Application no: H08-0025-11

Description: Brick round block outbuildings and replace double pitch roof with single pitch roof
(retrospective)

Location: Wargate Lodge
Wargate Field Lane
Gosberton
Spalding Lincs
PE11 4HJ
PE11 4HJ

Amendment: Elevation is facing brickwork only
(dwg. no. JWM/WL/0010A)

Project JWM/WL/0010	Sheet PROPOSED ELEVATION
Date 21/12/10	
Scale 1:50

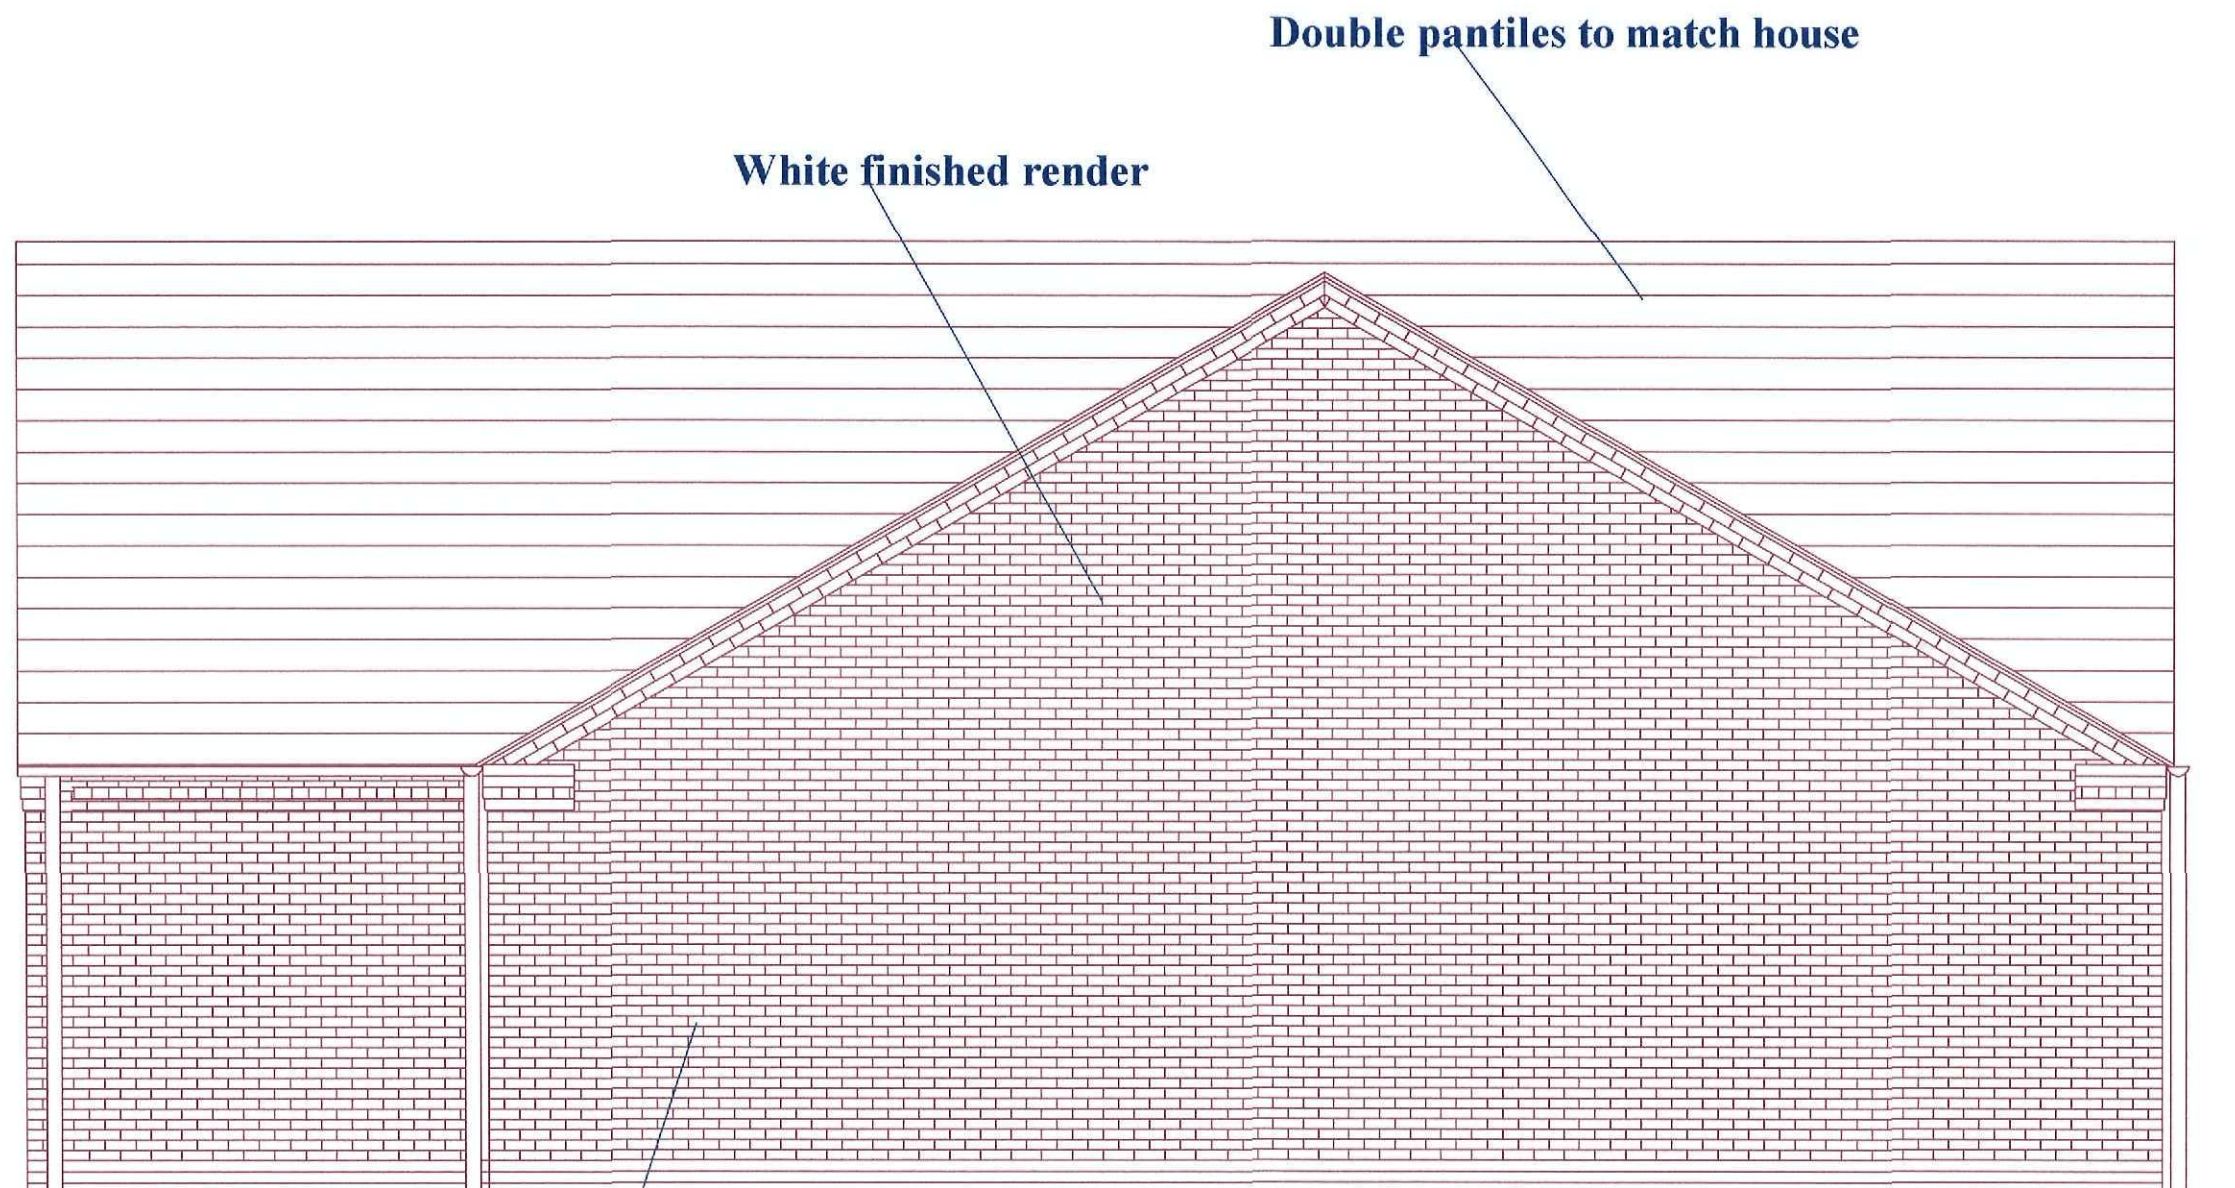
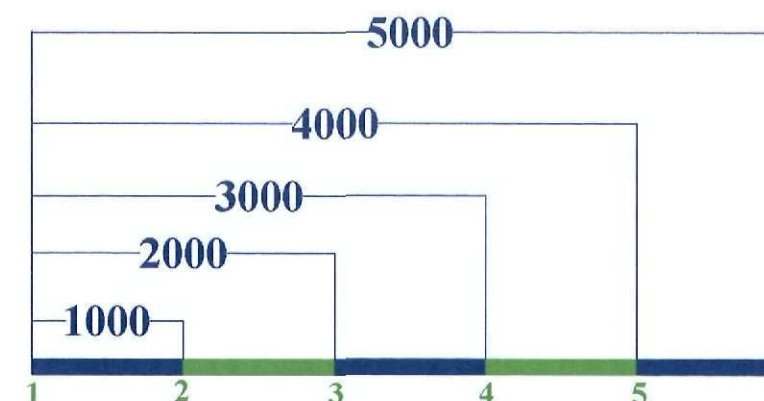
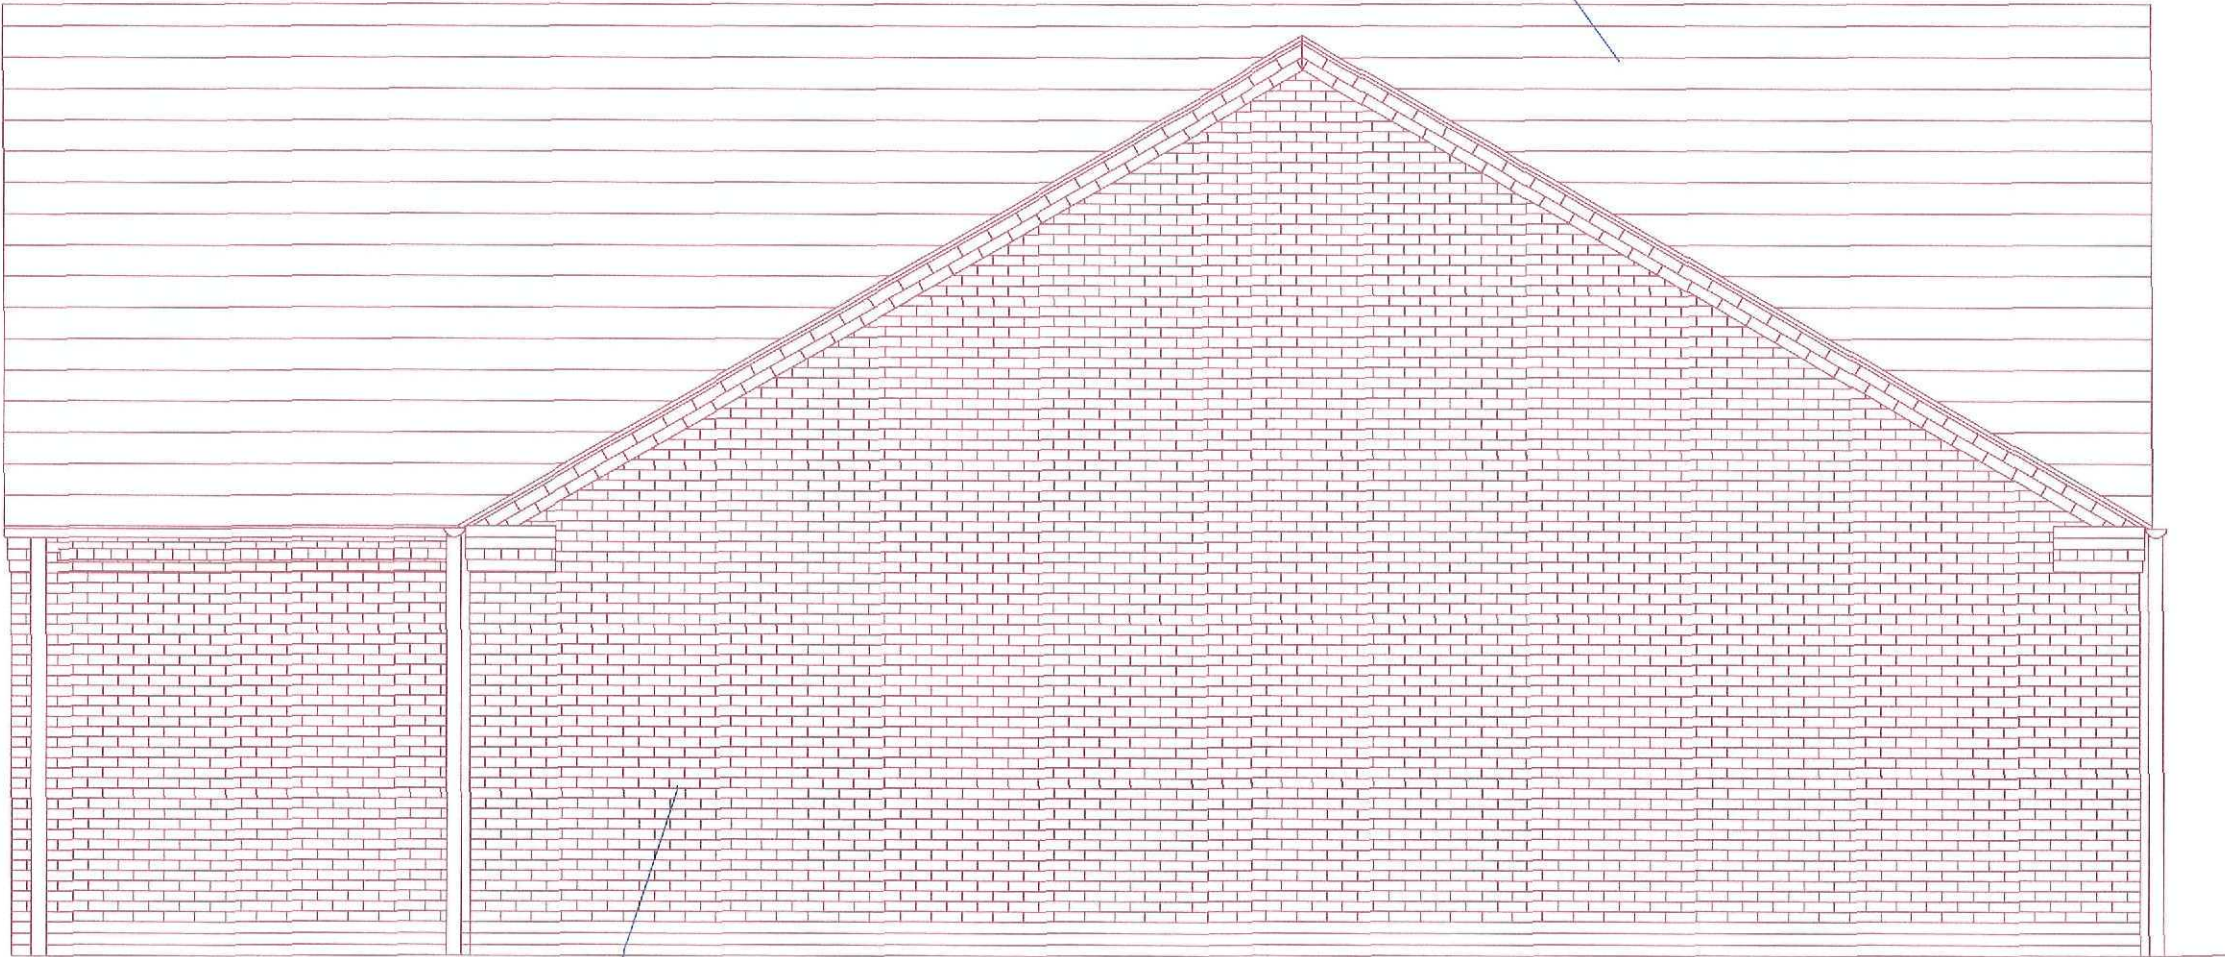
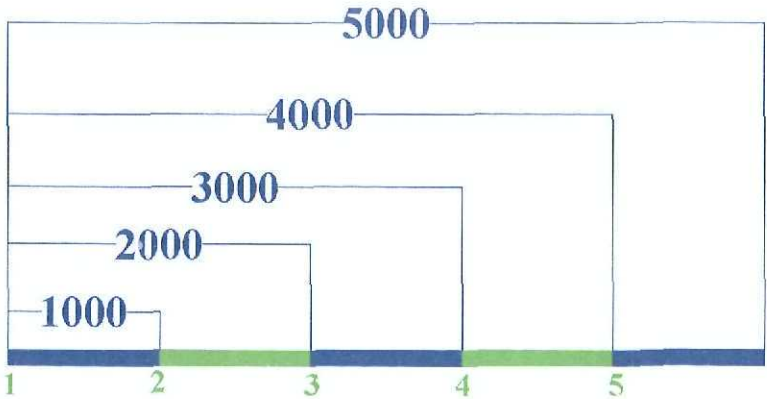
It has been brought to my attention that drawing JWM/WL/0010 has been annotated with both white render and facing brickwork. This elevation is in fact only facing brickwork. I therefore enclose 2 copies of a revised drawing with the notation of White Render Removed
